From: Amber Willard <Amber.Willard@arun.gov.uk>
Sent: 24 January 2020 09:11
To: Planning.Responses <Planning.Responses@arun.gov.uk>
Subject: FW: OBJECTION to modified gateway application AW-250-19-HH 19 Kingsway
Importance: High

FURTHER OBJECTION TO AW/250/19/HH AND APPLICATION TO WIDEN GATEWAY TO 3.5M

Proposed

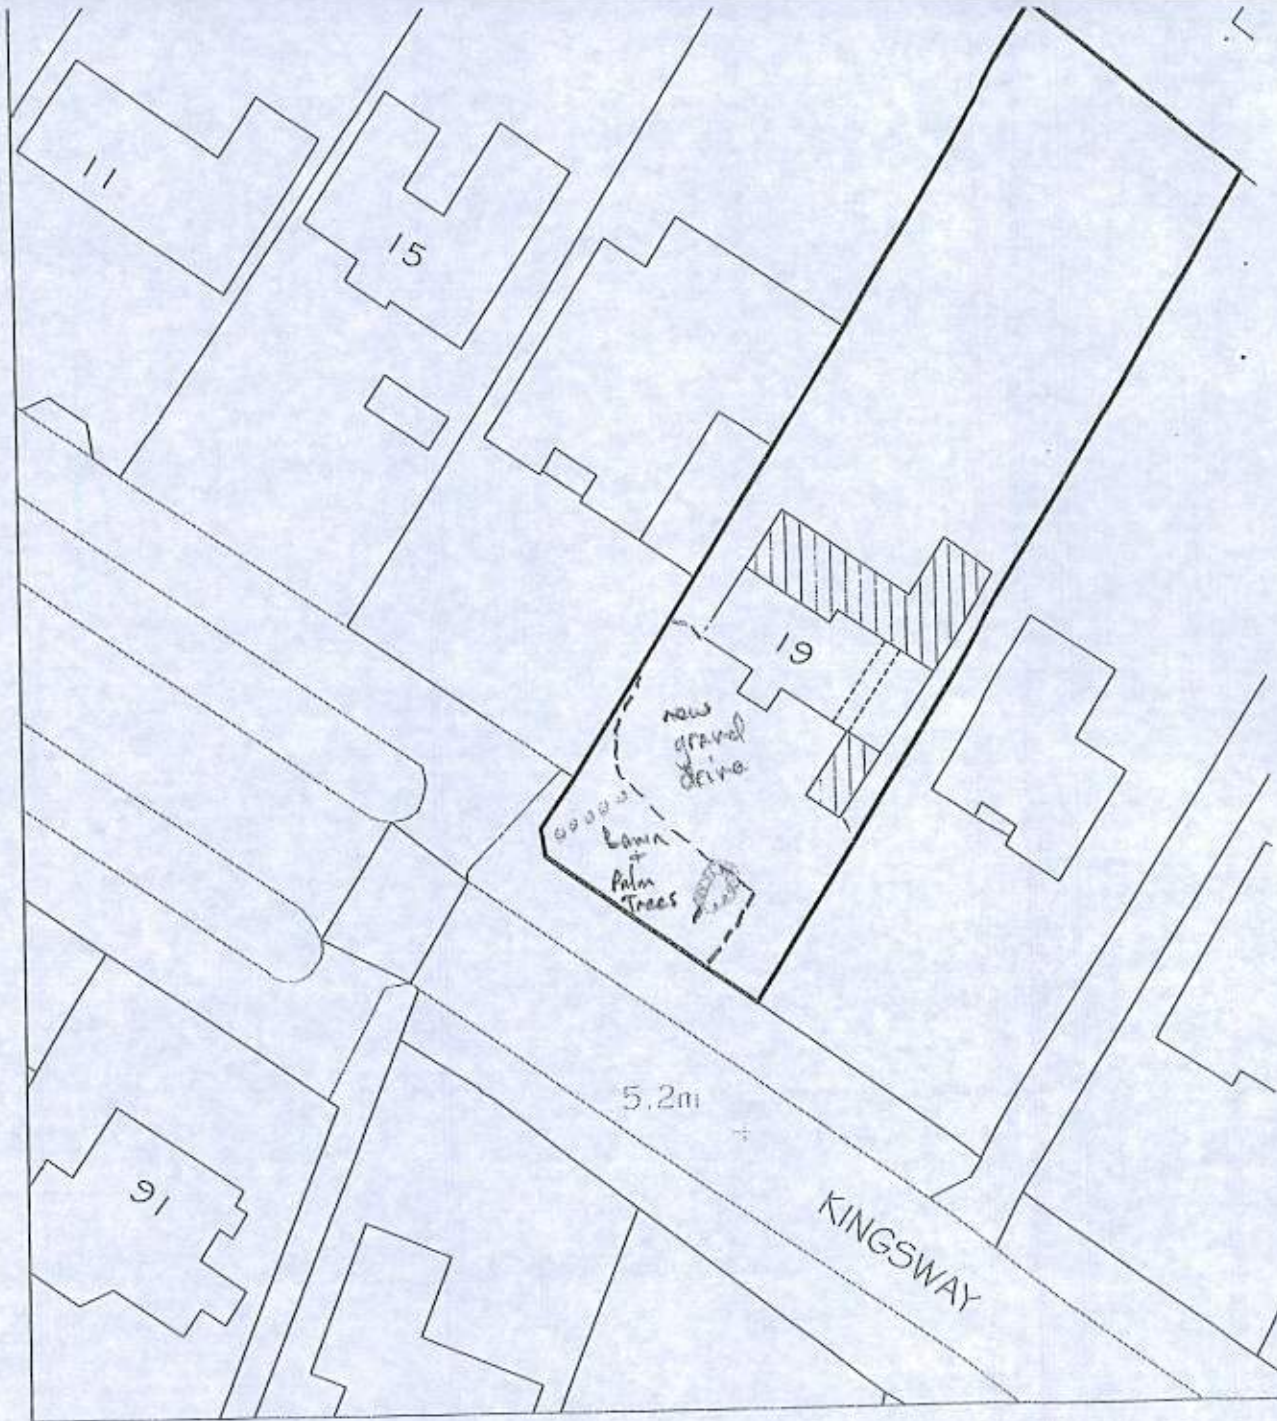
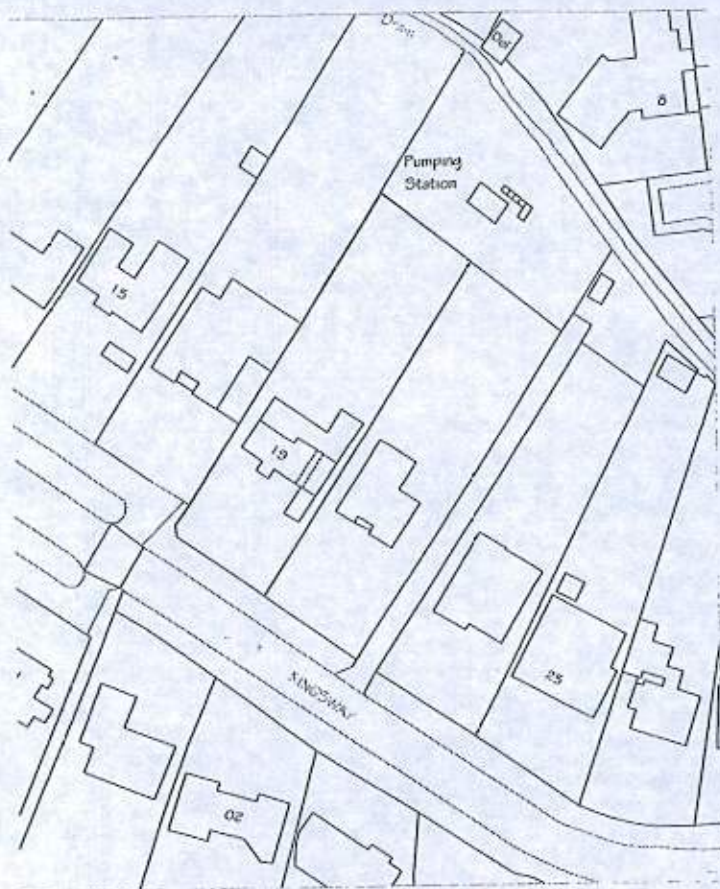
Without a verge, residents are free to walk upon and use the verge and do. THE PROPOSED GATE, OF WHICH THERE IS NO DETAIL - BUT IS THE SIZE OF A FARMING TIMBER 5 BAR GATE – CANNOT OPEN inwards BECAUSE OF THE GROUND LEVEL RISING. To have it opening OUTWARDS will be to block to public footpath owned by a third party, right out to the roadway and this is an outrageous concept in the name of DEVELOPMENT – TOTALLY UNACCEPTABLE AND VEHEMENTLY OPPOSED BY RESIDENTS.

Allowing this form of farmyard development within the prestigious Craigweil House CA brings no positive contribution and fails to retain an historically significant boundary (87 years) and harms views into the property.
